**56 Pine St. Amendment BP# 2017-00426 plan review comments**

**58 Pine Amendment Deck.pdf**  
120K

① NORTH ELEVATION  
3/16" = 1'-0"

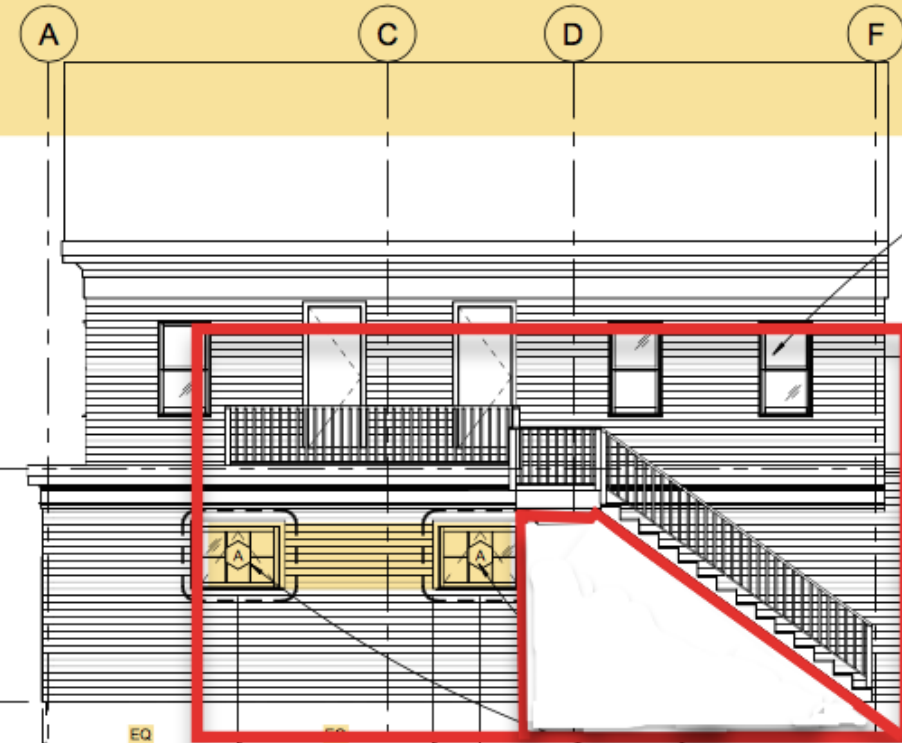
This detail will not meet code as there needs to be one continuous graspable handrail without interruption, this can be attached with brackets and returned to the posts at the top and bottom at a height of 34"-38" off the tread nose. Please confirm.

Please provide at least a marked up photo of the landing support framing details. None of the elevations either from the original permit or the amendment show this perspective. I don't follow what you mean by the post dropping onto Galvi standoffs, are there also vertical posts in addition to angled?

I also have concerns about the skirting enclosure as this cannot be used as a storage area under egress stairs. Will there be an access door to this space? I understand historic needs, however this may promote a storage area that is not allowed under stairs, please confirm.

Will the roof deck be attached to the building, and how?

Will you be posting down to sona tubes? What is the existing base? Frost protection is required.

1. The guardrail design will be approved per the historic guidelines. Due to the interruption at each intermediate post, this cannot be considered the graspable handrail due to a break in continuity. One separate circular or other graspable shape per code will need to be installed at 34"-38" above the tread nose either on the building or on the balustrade. The ends need to be returned to the post or wall at the top and bottom.

2. The stair can have an open slat enclosure underneath with an access door as per historic design approval, however I will put a condition of approval that the enclosed space cannot be used, with a sign on the inside stating this and access is

3. The risers are to be solid or partially open with less than 4" of space.
4. The landing posts are to be supported on frost protected piers.

This detail will not meet code as there needs to be one continuous graspable handrail without interruption, this can be attached with brackets and returned to the posts at the top and bottom at a height of 34"-38" off the tread nose.

Ok, we don't care what the railing is. Rob at Historical was saying he wanted this. So I guess I'm stuck in the middle? Initially I just wanted to replace what's there, which is what your

Pardon me, I should have said "post base" <http://www.homedepot.com/p/Simpson-Strong-Tie-ABA-4x4-ZMAX-Galvanized-Adjustable-Post-Base-ABA44Z/100374999>

There will be no need for angled bracing as the vertical post(s) will be taking the place. I can see using 3 vertical posts, 1 for each outside corner of the landing and 1 breaking the span of the outside stringer.

This was another Historical advisement from Rob. Wanting us to do a slated design under the landing and under stairs. There was talk of a door. Wasn't so much intended to be a storage space.

We would use adhesives to secure the sleepers of the deck to the rubber roof. I would prefer not to penetrate the rubber roof as that is why we are replacing it... The landing is secured with lags through a 2x8 ledger. The inside stair stringer would be lagged to the side wall as well.

Yes, we have no problem complying with these stipulations.
